Your ref:	12657 8 CRAVEN HILL condition...	Please reply to:	Mr Joshua Wilson
Our ref:	23/07340/ADFULL	Tel No:	
		Fee Queries:	0207 641 6500;
		Email:	planningreception@westminster.gov.uk;
Mr Brian Gatenby Get Planning and Architecture Ltd 7 Tudor Court Brighton Road Sutton Surrey SM2 5AE United Kingdom		Incomplete Applications Town Planning & Building Control City of Westminster PO Box 732 Redhill, RH1 9FL	
		31 October 2023

Address: 8 Craven Hill, London, W2 3DS,

Proposal: Details of elevation and section drawings showing the new windows (including break lines in the drawings if required) including glazing bar details and including the relationship of the windows to the external wall of the building and also any rebates present in the wall surrounding the window openings pursuant to Condition 4 of planning permission dated 3rd August 2023 (RN:22/05545/FULL) (Linked to 23/07290/ADLBC)

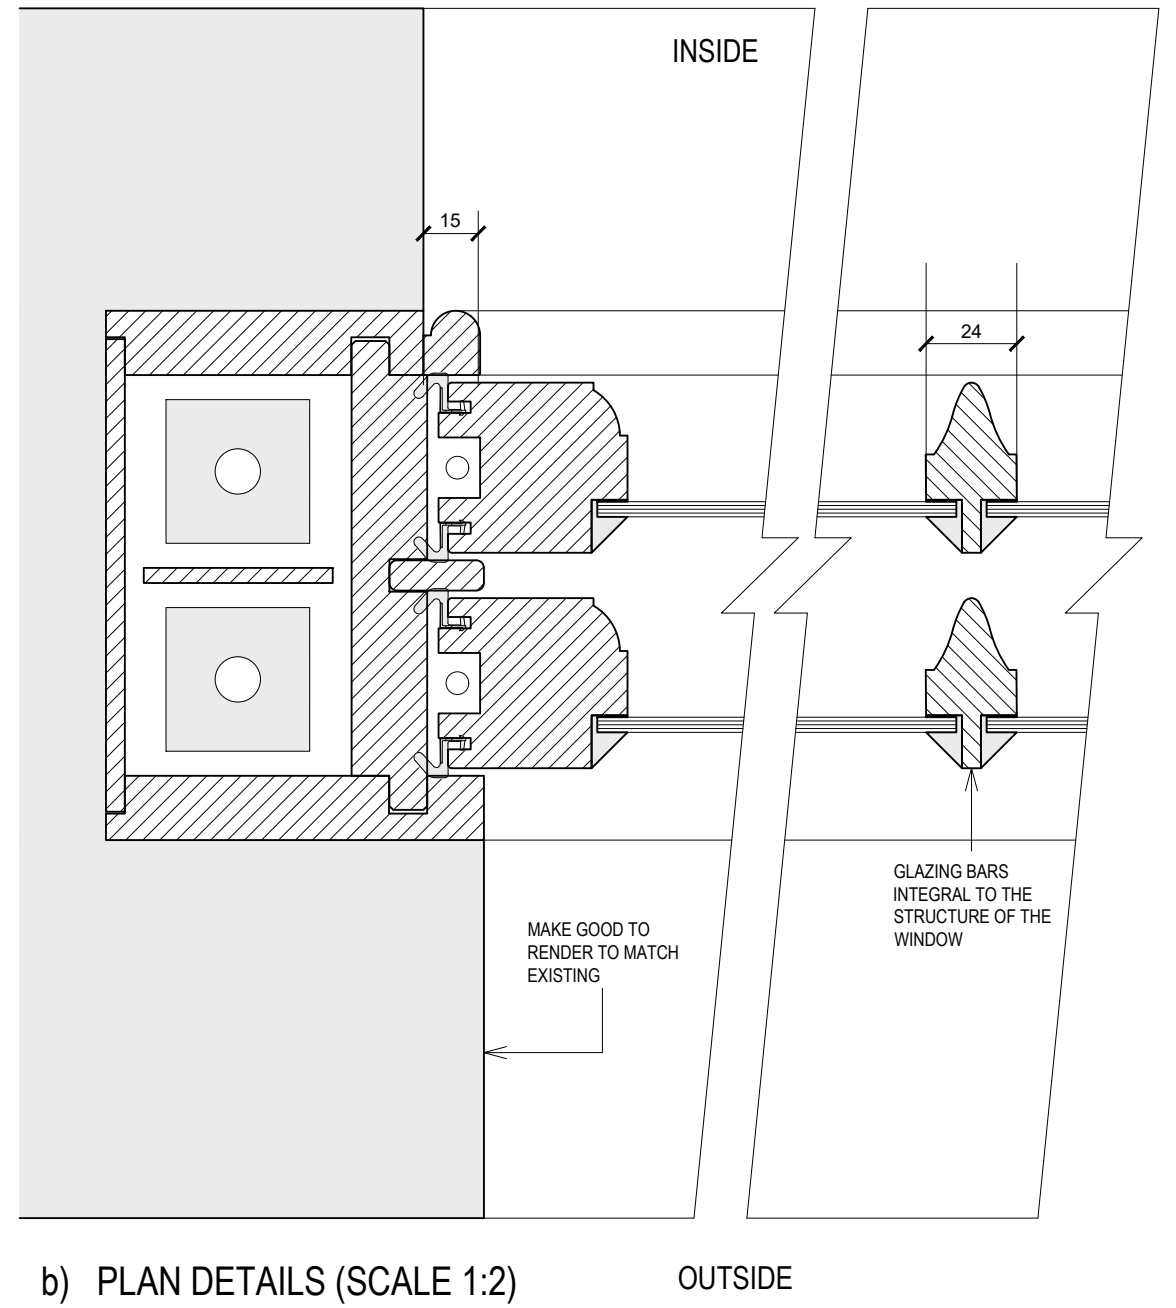
- Please can you confirm if you are using putty detailing externally to the window framing in traditional manner?
